30 June 2025

**RE: SSD-82548708 Residential Flat Building with Infill - Affordable Housing - 24,26 &28 Middle Harbour Rd Lindfield – 94 Apartments**

Drawing Name
Deep Soil Diagrams

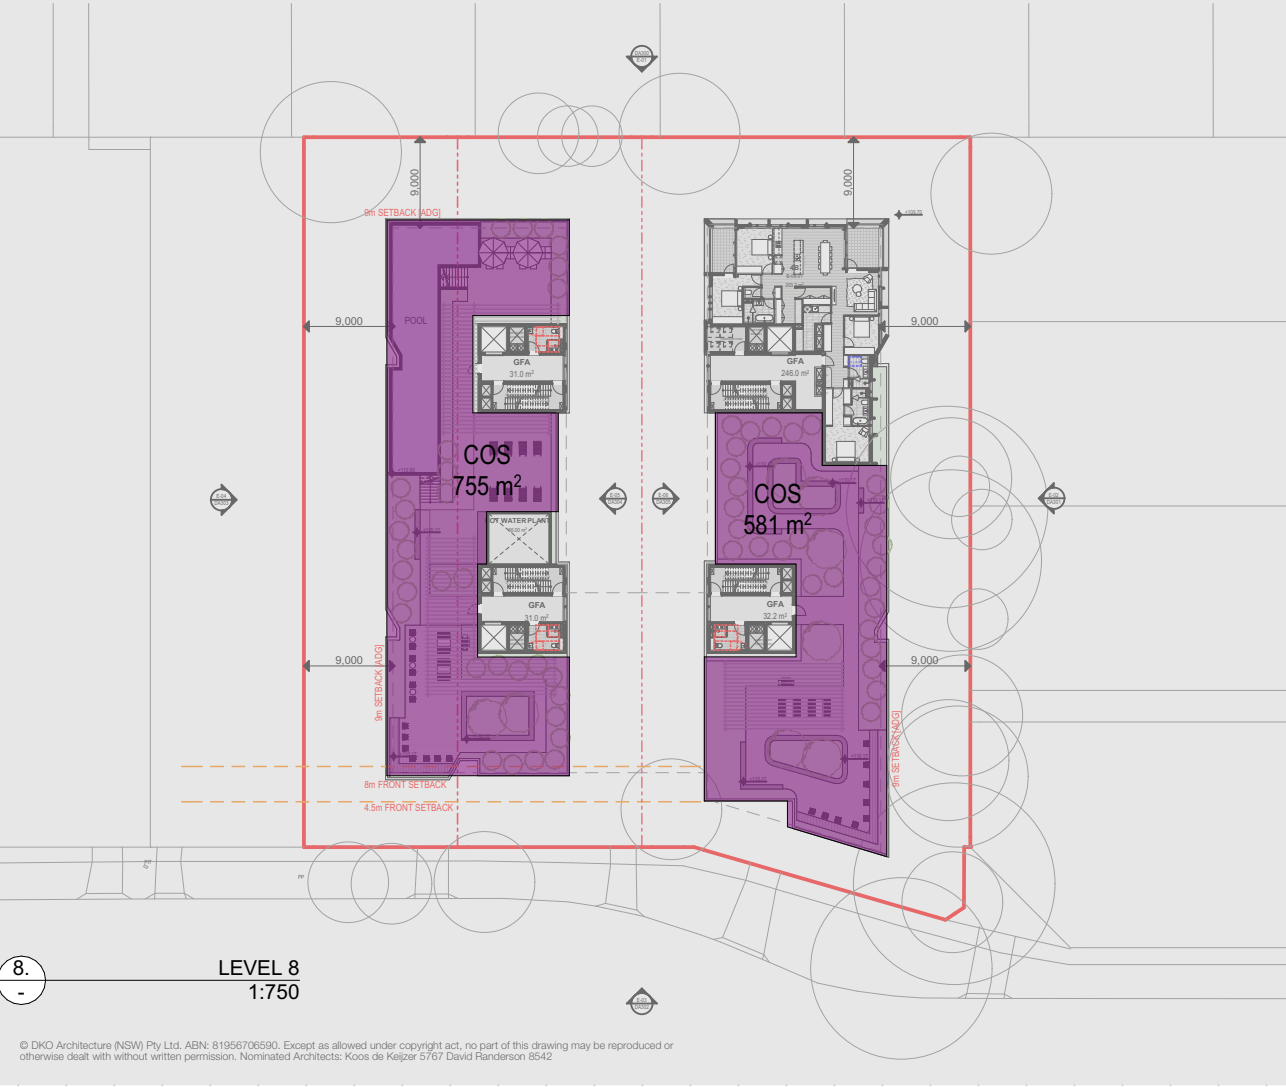
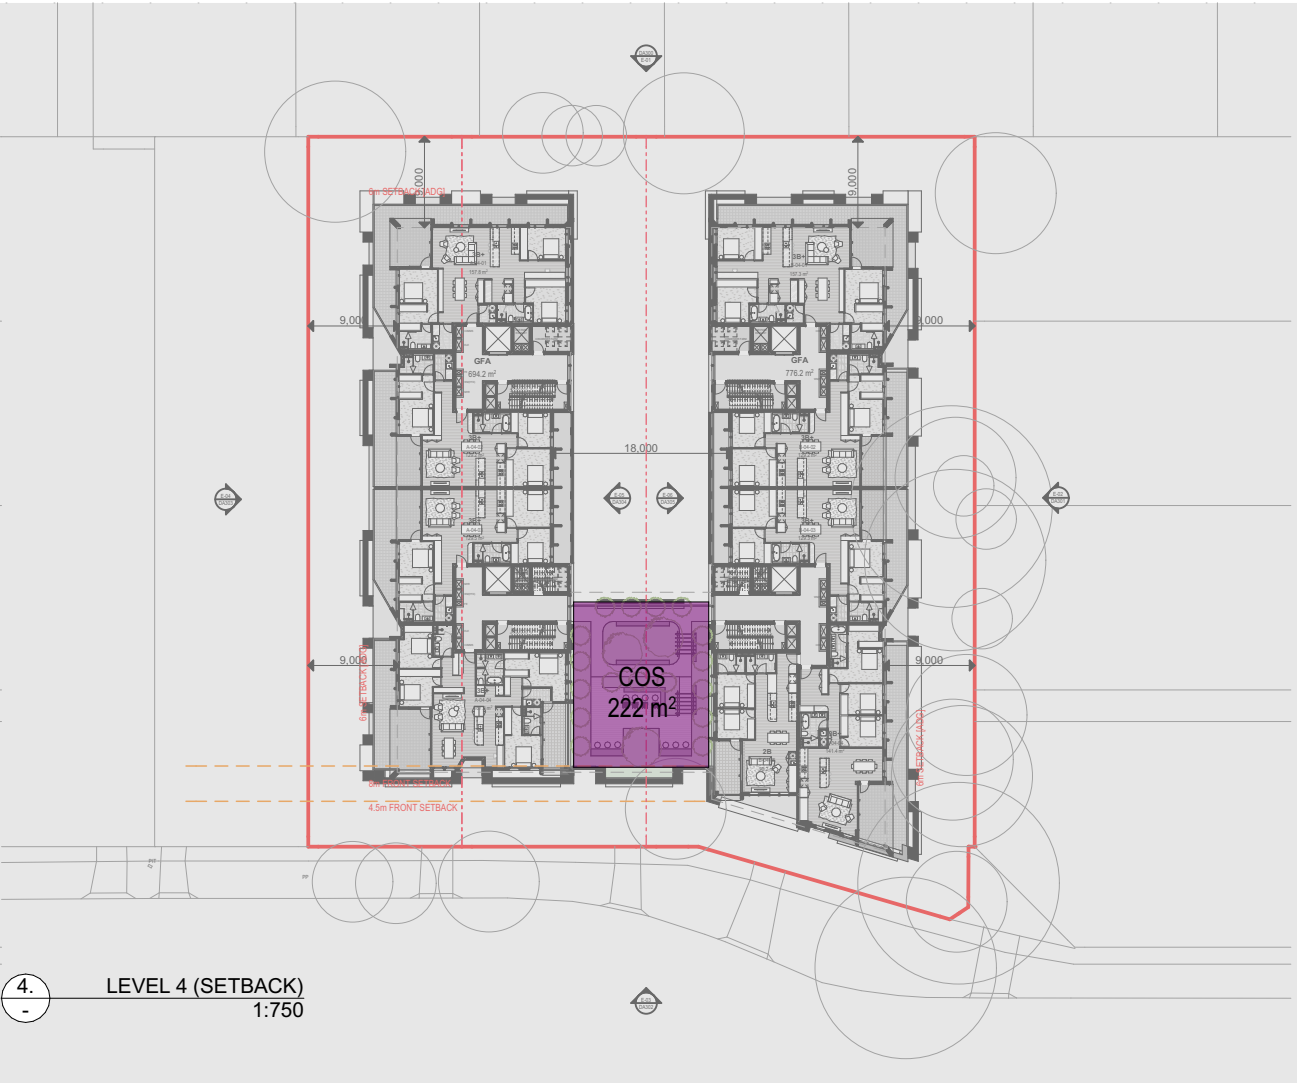
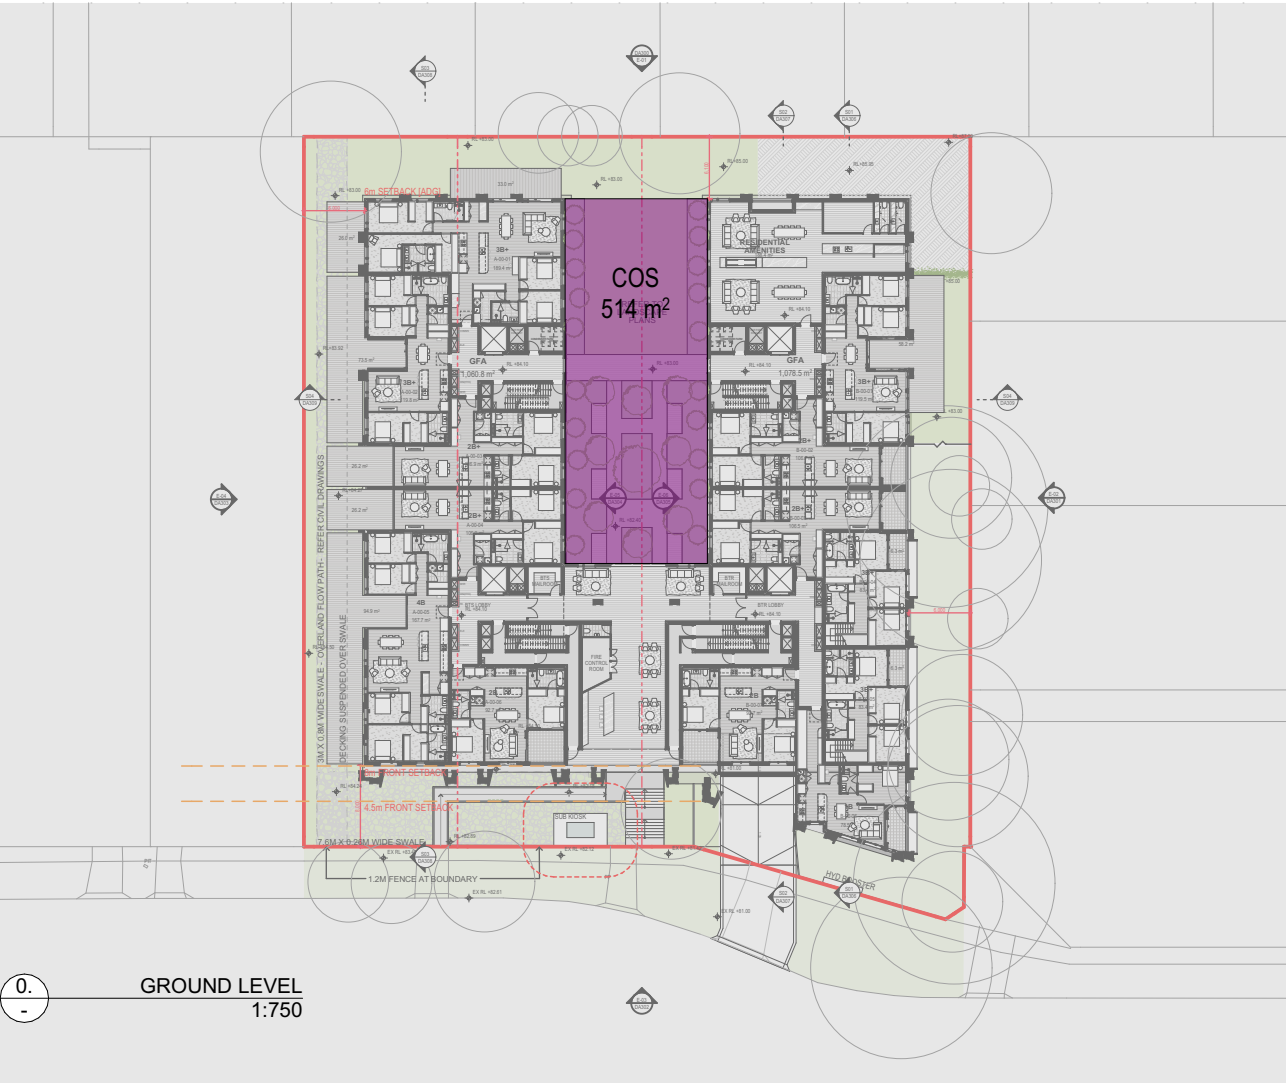
- Excessive site coverage in excess of the DCP controls. Site coverage of 30% is exceeded by more than 100%, with an estimated 70+% site coverage. The site coverage comment of 44% in the EIS must relate to another development.
- Deep soil cover should be a minimum of 50%, but is halved to only 28%
- The site is classified to have an FSR of 1.3:1 under the Preferred scenario, not the 3.25:1 of this proposal.
- Its location next to a Heritage Item and Trafalgar Avenue Heritage Conservation Area and its associated requirements are not met.
- The streetscape and strategic context as required in the DCP are ignored
- Communal open space is increased from DCP setting of 10% to a proposed 43% that will impact the noise and privacy factor for the immediate vicinity and adjoining properties.

- 3E Deep soil zones- Deep soil of 1383m<sup>2</sup> (28.3%) will be unlikely to allow for tall tree canopy to develop.
- Housing SEPP requirement for residential flat buildings to provide a minimum of 9m from the side and rear boundary up to the fourth level when located next to lower density residential development are not met.
